Subject: Planning consultation - AL/67/25/PL Nyton Rest Nyton Farm Shop Nyton Road Aldingbourne PO20 3TU

Ian Stocks
Water & Access Manager - Protection
West Sussex Fire & Rescue Service

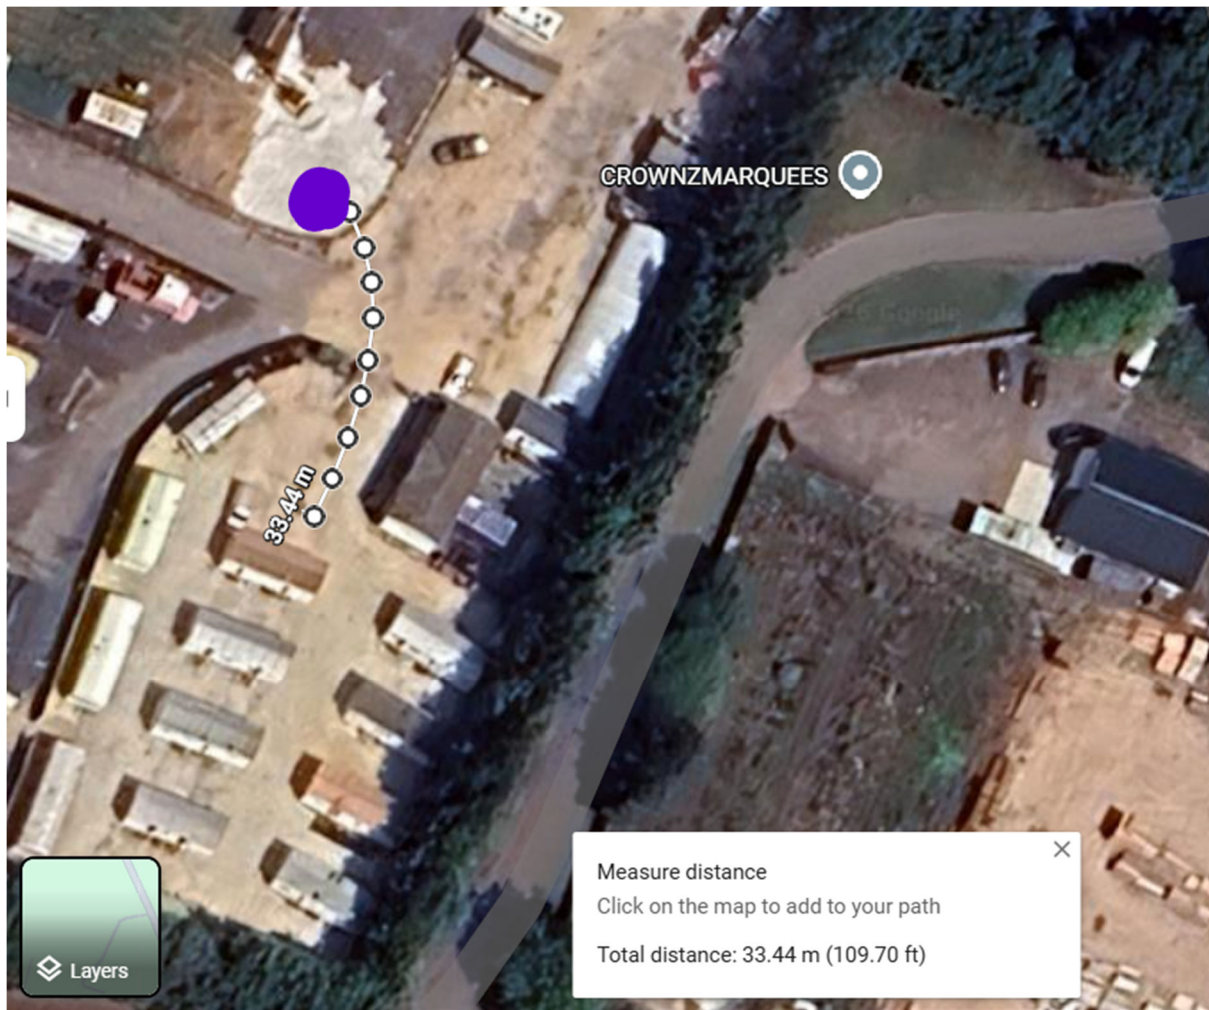
Evidence will also be required to show the Fire Service vehicle access meets with the requirements identified in Approved Document B Volume 1: B5 Section 13, including Table 13.1 and diagram 13.1. A fire appliance requires a minimum width of 3.1m through any gateway or narrowing and 3.7m between road edge or curbs, capable of supporting 18-Tonne axial weight of a fire appliance and a suitable turning facility to enable a fire appliance to exit the site in a forward direction.

Although this is the change of use, it is a significant change with no supply of water for firefighting available within the required distance, increasing the risk to life and property in the event of a fire, information the owner may not be aware of, and information that could affect their insurance premiums if water for firefighting is not provided. This would also benefit the other units on the site.
